MEMORANDUM

TO: Jean Fraser, Planner
FROM: David Senus, PE
DATE: July 10, 2015
RE: Lot 5 Industrial Way, Final Level II Site Plan Application

Woodard & Curran has reviewed the response to comments and Final Level II Site Plan Application for the proposed Office building located at 81 Industrial Way in Portland, Maine. The project involves the construction of a 9,900 SF building, a 75 space parking lot, and associated site improvements.

SITE PLAN
OF:
LOT 5 INDUSTRIAL WAY
81 INDUSTRIAL WAY
PORTLAND, ME 04103

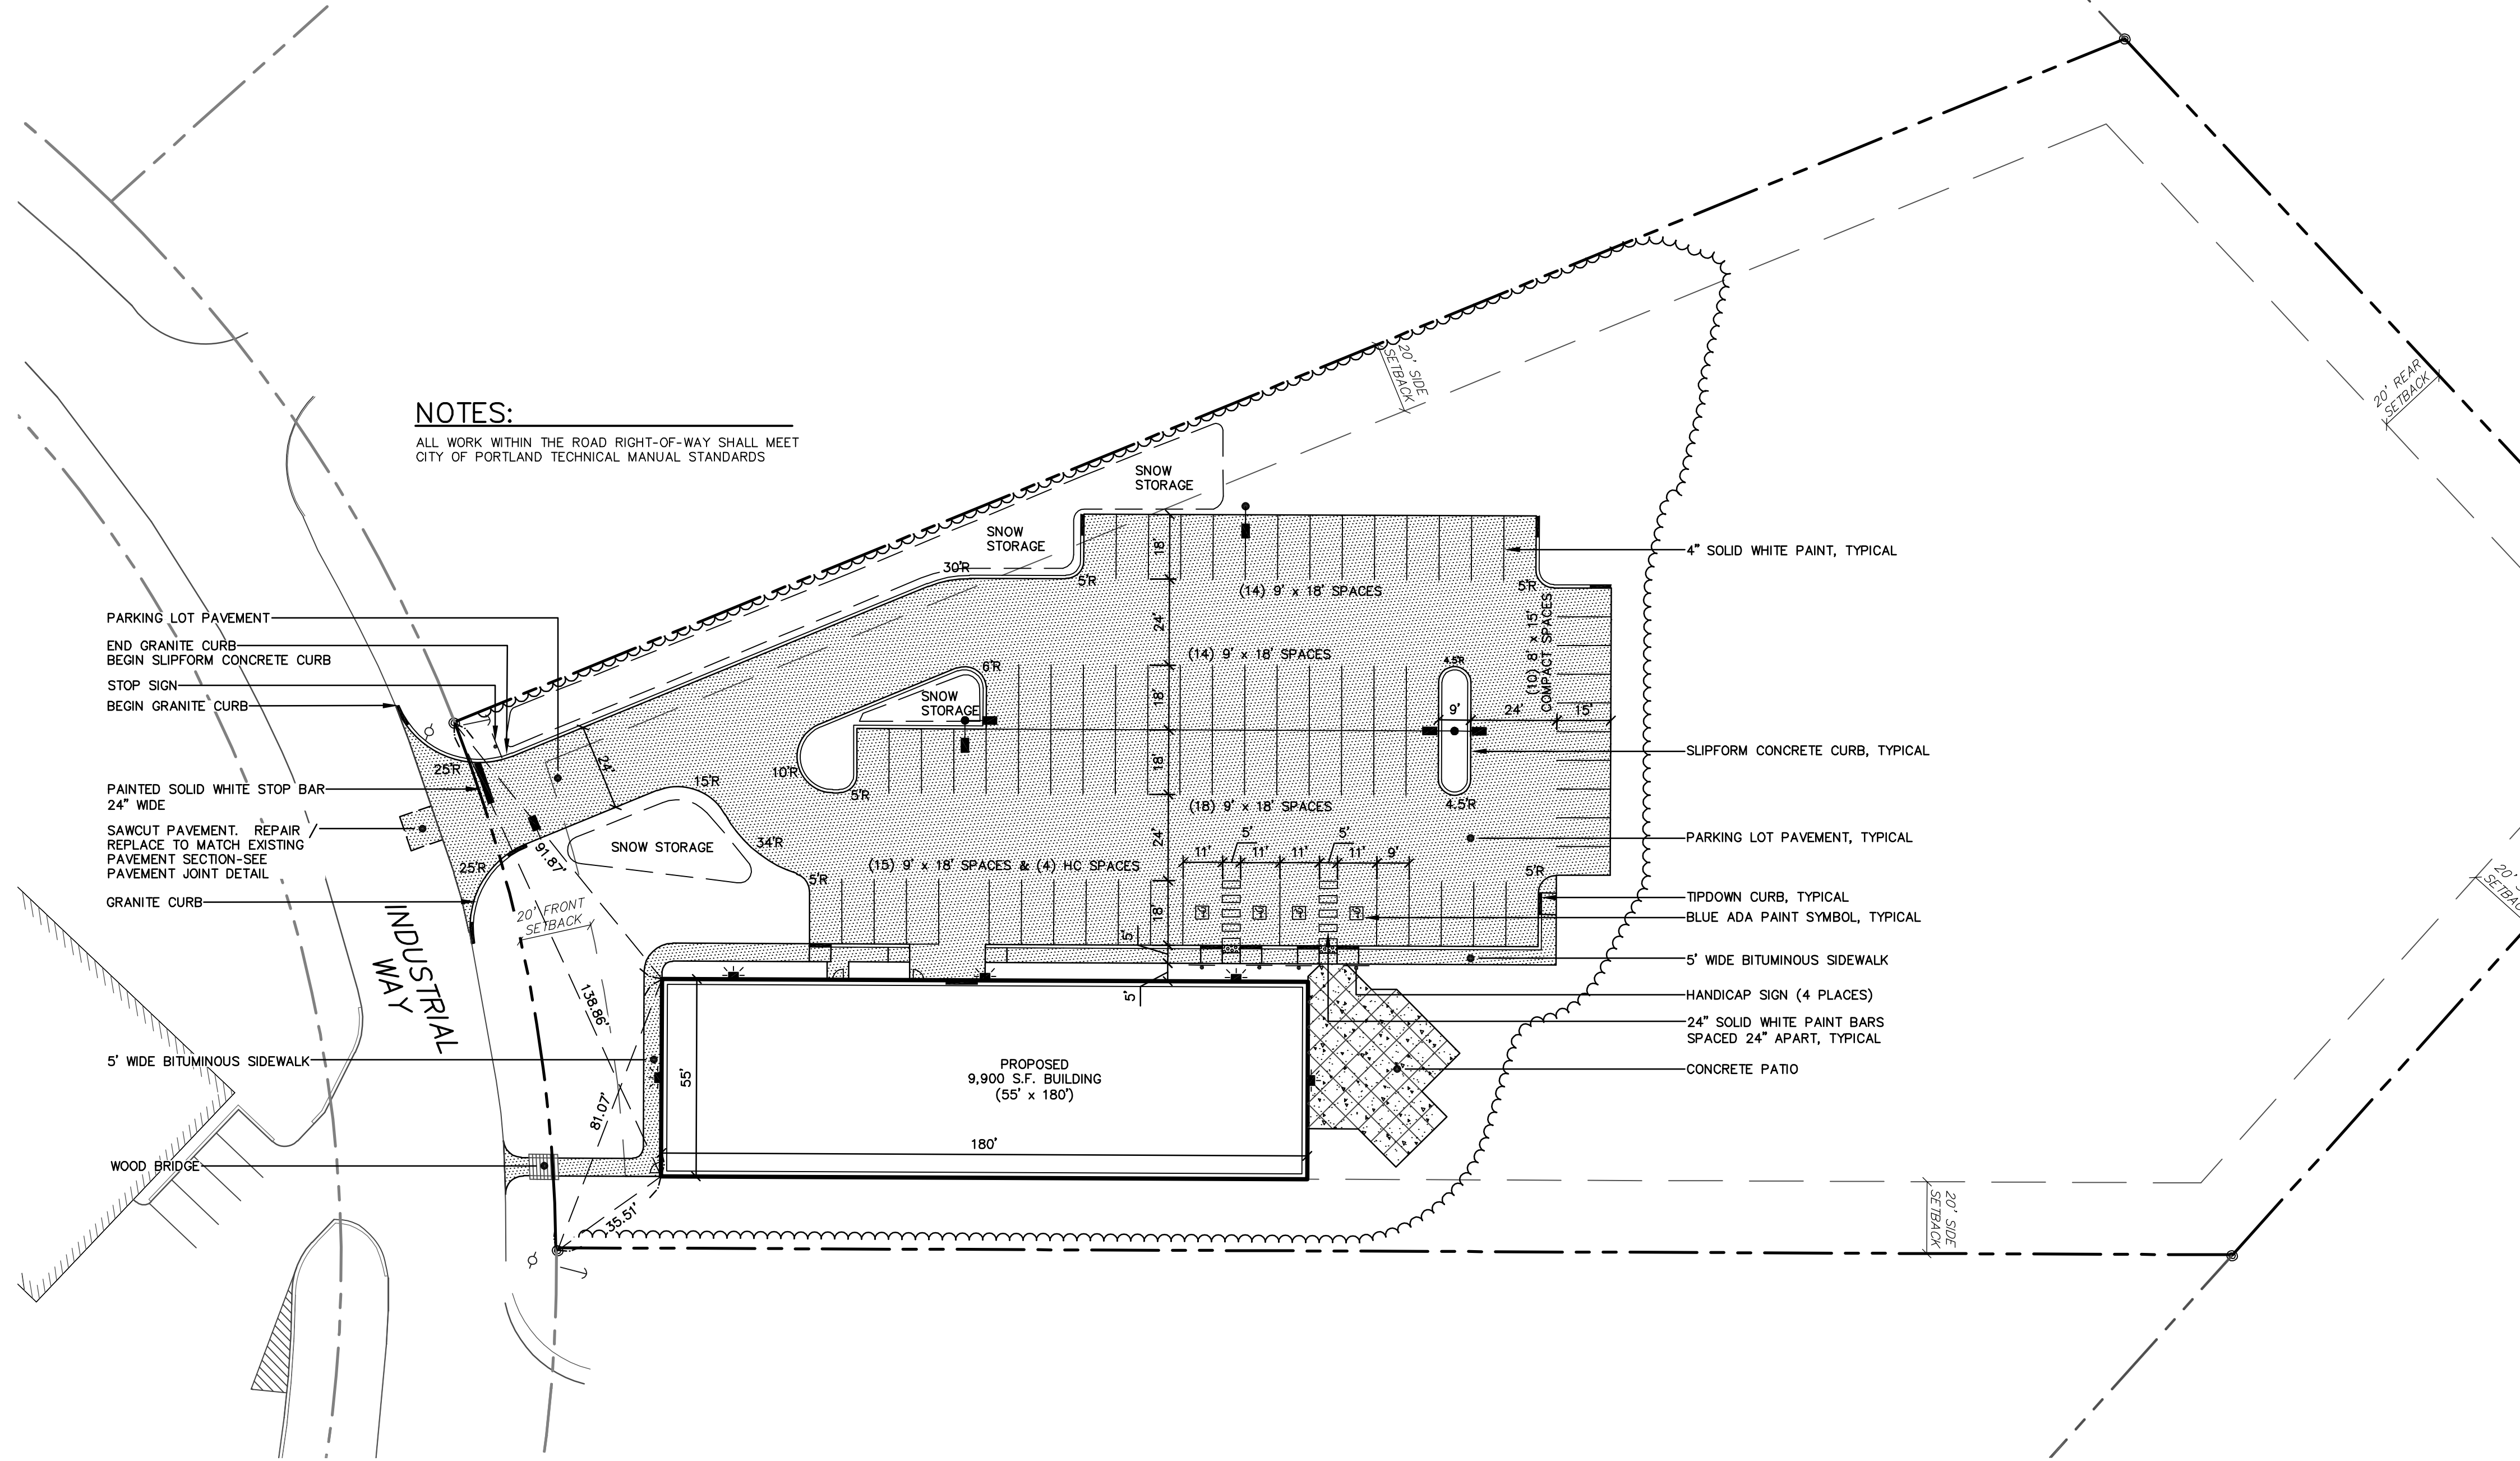
- 1) HDPE is not an acceptable pipe material within the City ROW for the driveway cross culvert; refer to allowable pipe materials listed in the Technical Manual, Section 2.5.2. The culvert is proposed with minimal cover, the Applicant should consider lowering the culvert to achieve more cover.
- 2) The Applicant has noted that a copy of the Portland Water District's confirmation of the ability to serve water and the City of Portland Public Services Department's confirmation of ability to serve wastewater flow will be forwarded upon receipt.
- 3) The Applicant has noted that they will forward a copy of the ACOE's approval for project wetland impacts upon receipt and will forward a copy of the Notice of Intent to Comply with Maine Construction General Permit once filed with the MaineDEP.
